Designing Out Crime Officer

Thames Valley Police

28 June 2024

Reference: 24/01372/F

Drawing Title. **UNIT 13  
ELEVATIONS**

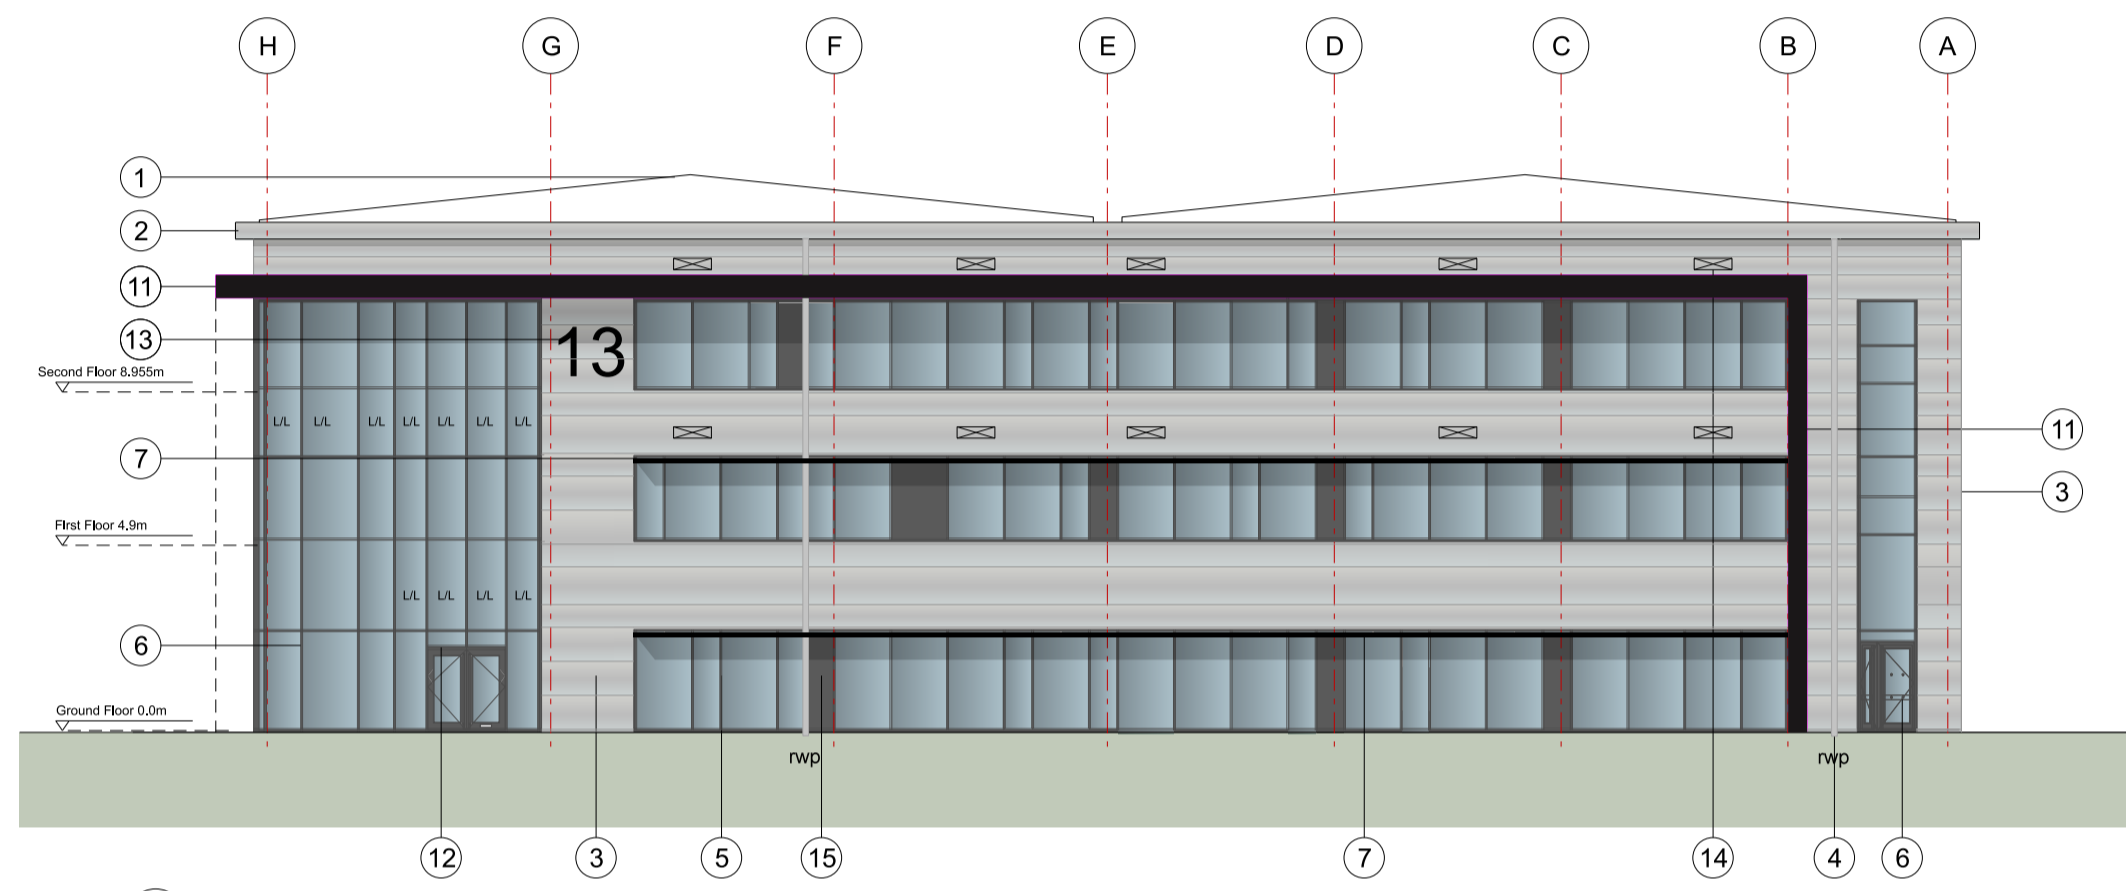
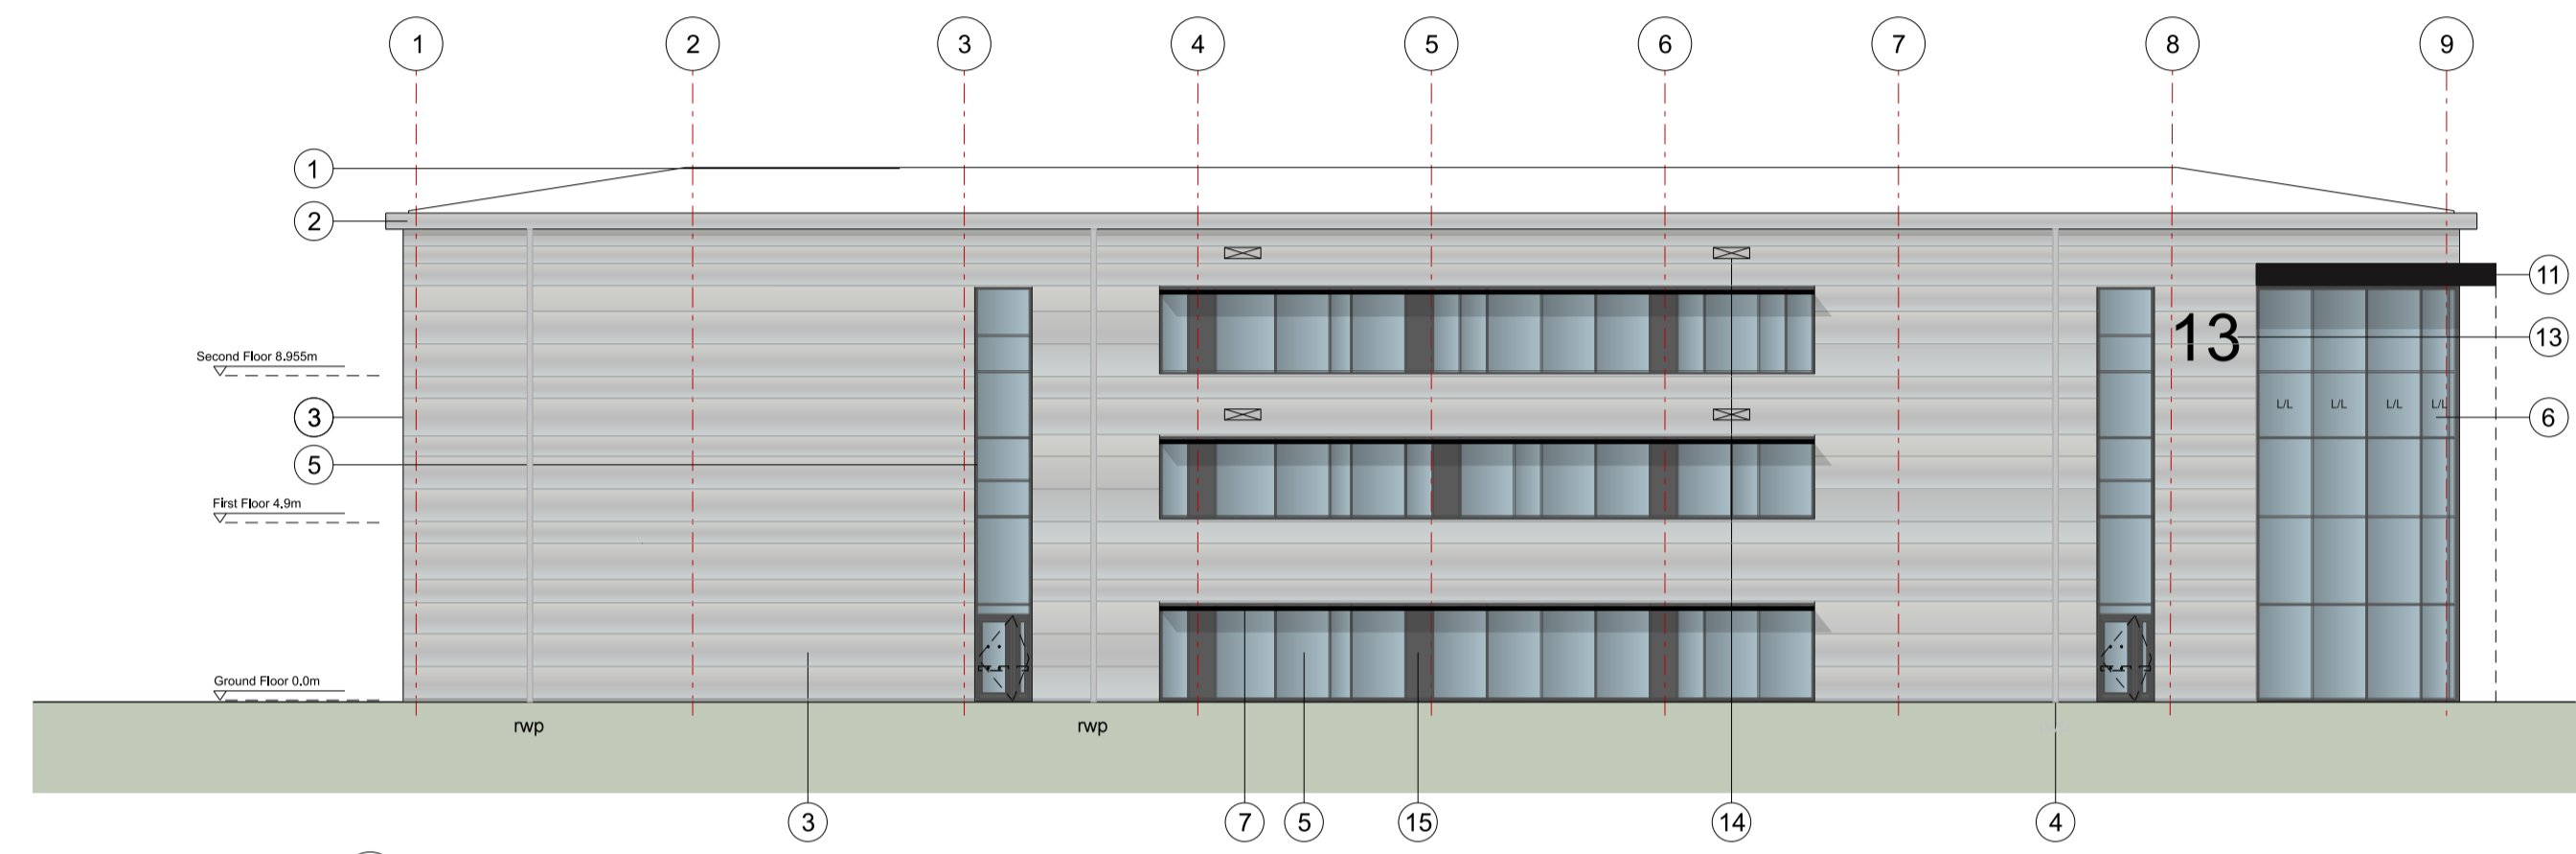
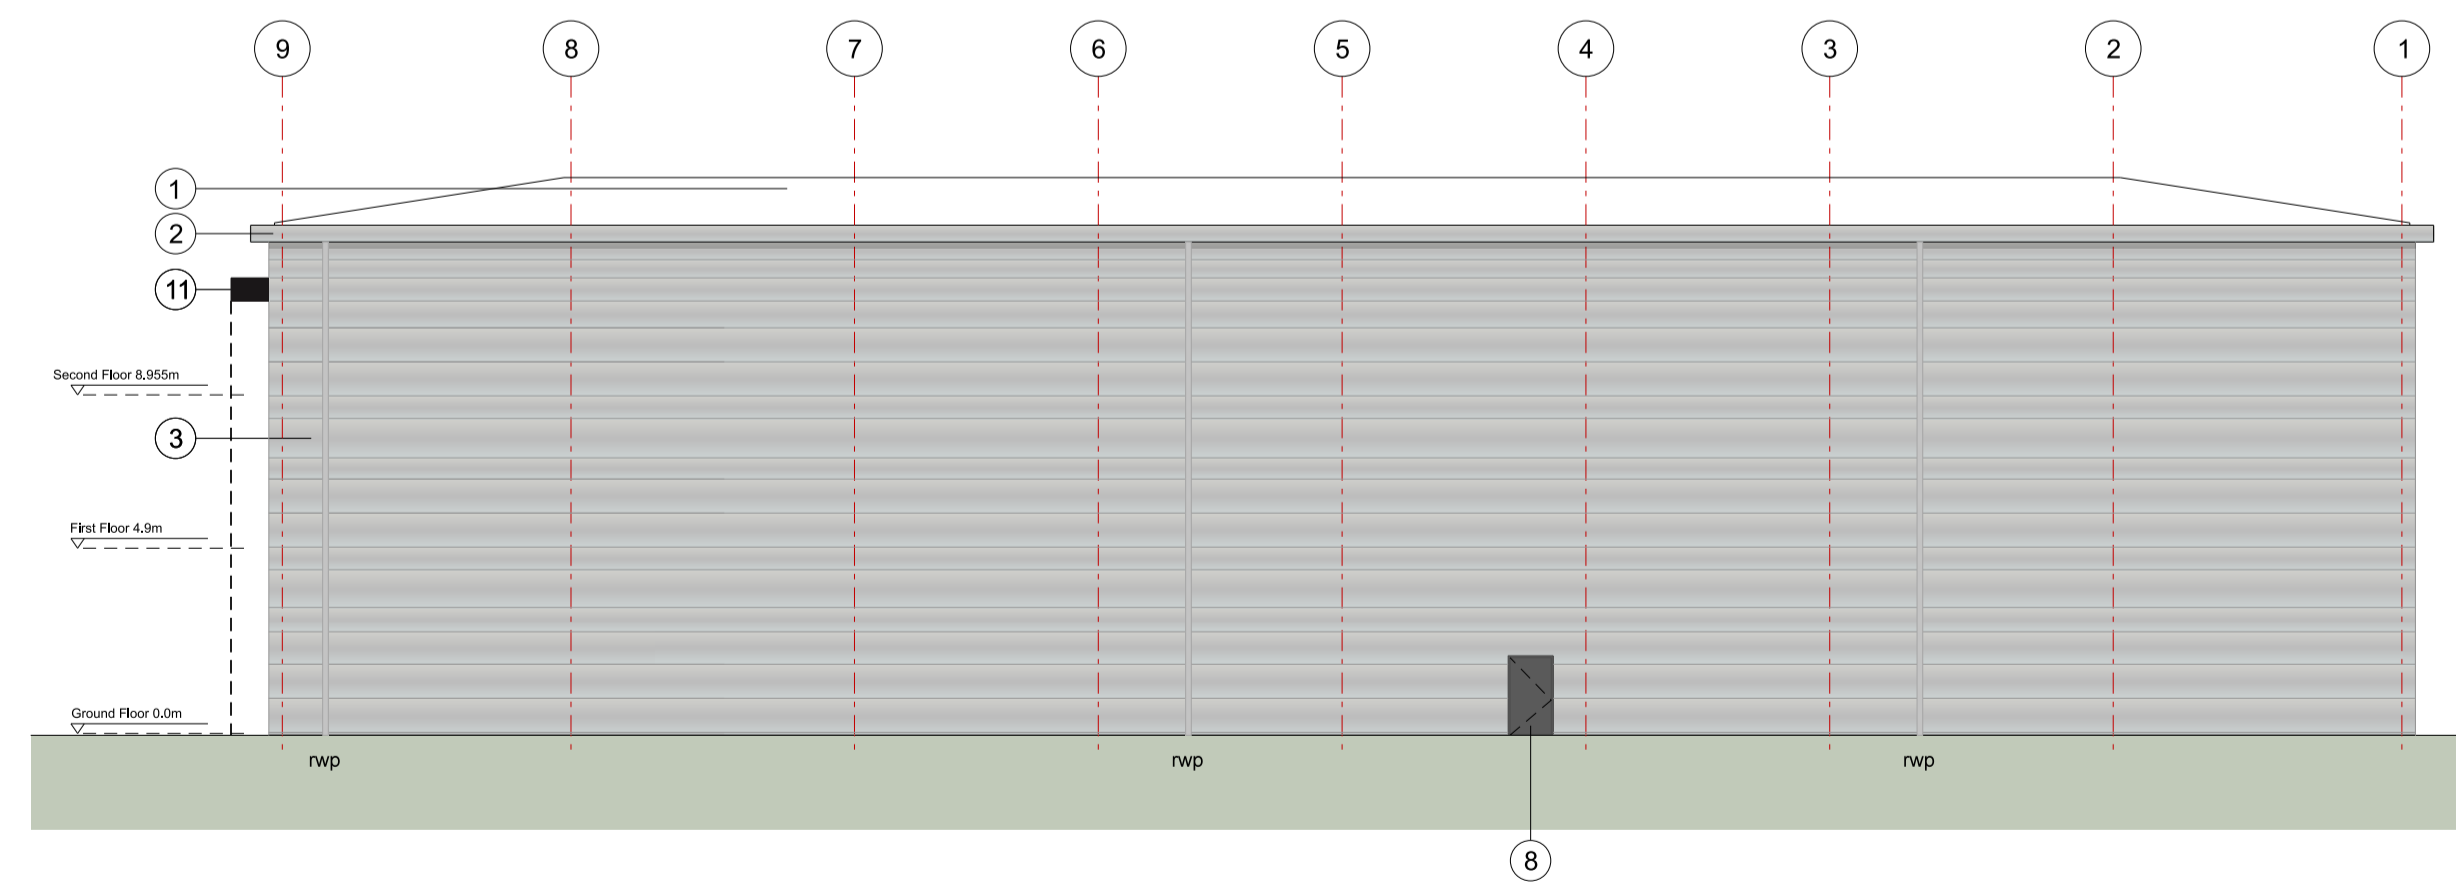
• The envelope of the units have large sections of glazing directly accessible from the road, leaving them vulnerable to ram raid style attack. The buildings should be provided vehicle mitigation measures such as bollards along the perimeter where it abuts the road/car parking, to mitigate against this risk. Security bollards should stand a minimum of 1.2m high above ground level and be spaced with a maximum air gap of 1.2m between. The 1.2m gap between bollards should be measured at a height of 0.6m high. Bollards require significant civil engineering to be able to sustain the high forces upon impact and require proportional foundations, but where this is not possible due to obstructions laying beneath the surface there are installation schemes that provide shallow foundation technology.

02 UNIT 13  
007 south west facing - elevation

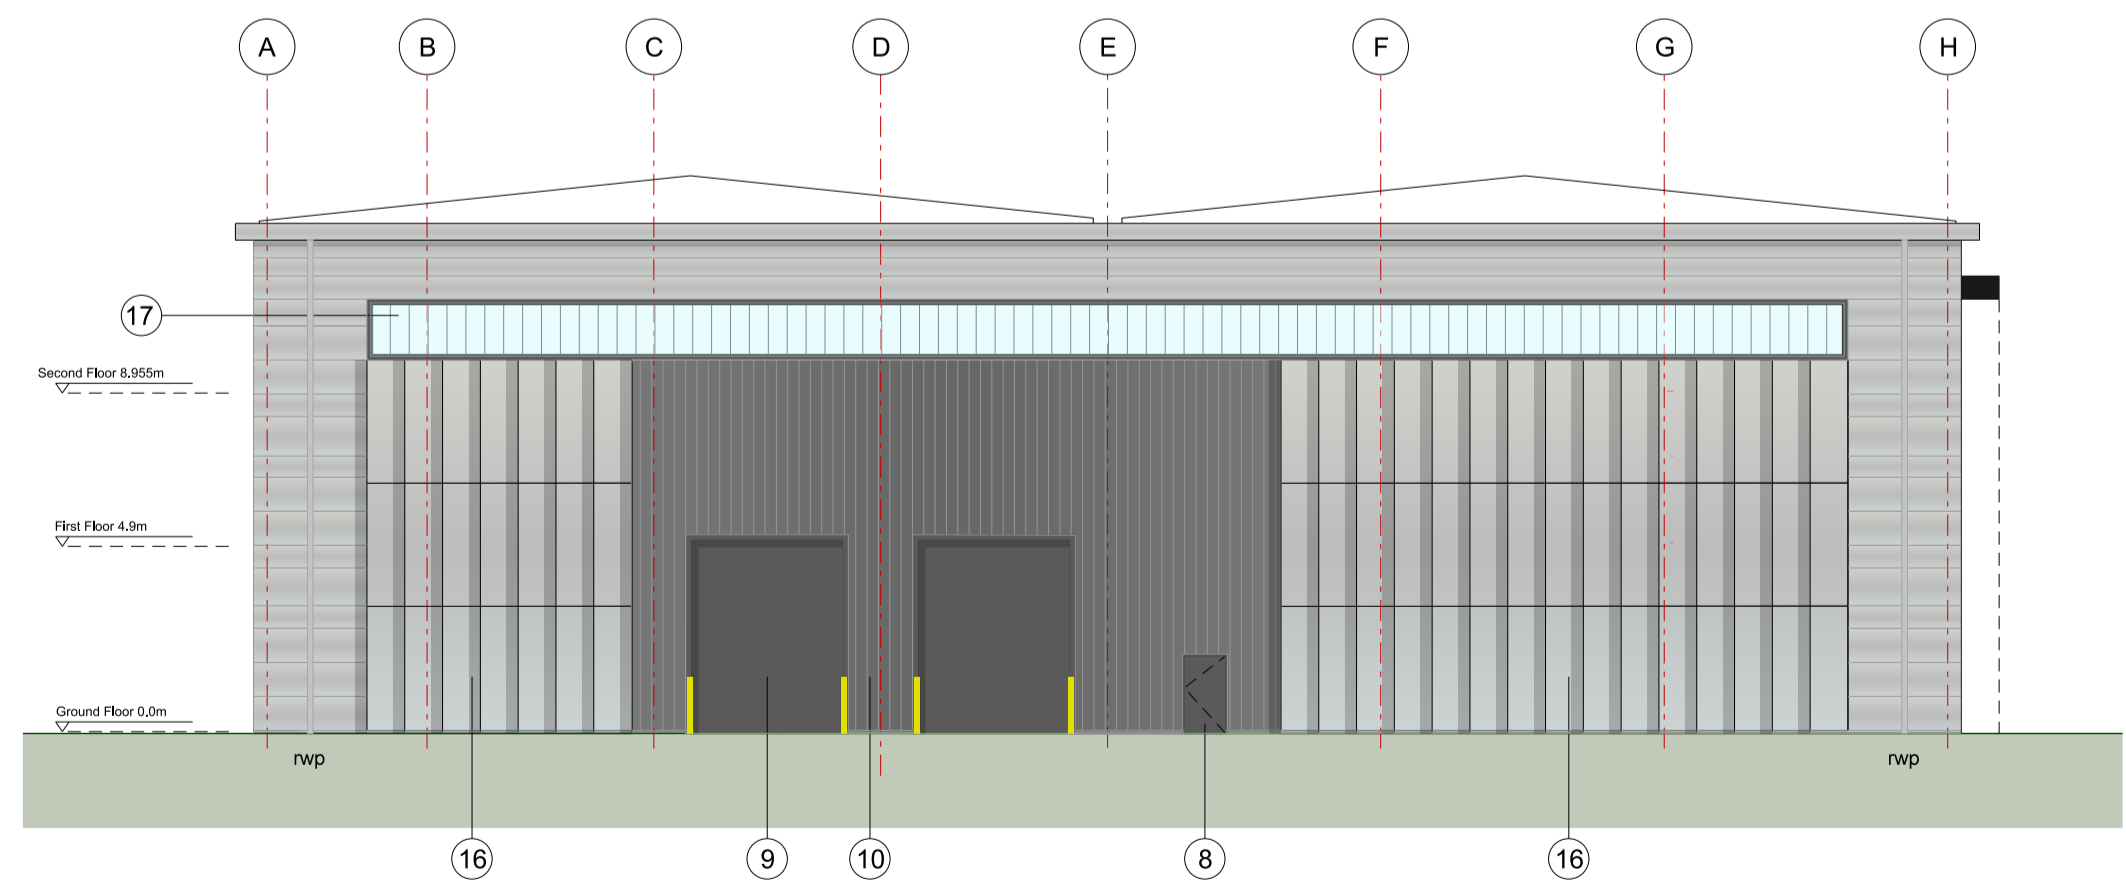
• Fire exits on the south-west elevation of Unit 13 are located in a secluded area devoid of surveillance and will be at higher risk of concealed entry attempts into the building. I recommend the external fire escape route is enclosed with secure fencing to a height of at least 2m, with secured gates to prevent unauthorised entry. This fence should extend the length of the south-western elevation. Emergency egress should be facilitated via crash bar or similar, and be mounted and installed so that it cannot be operated from the external side of the gate. All access doors into the unit should be covered by CCTV.
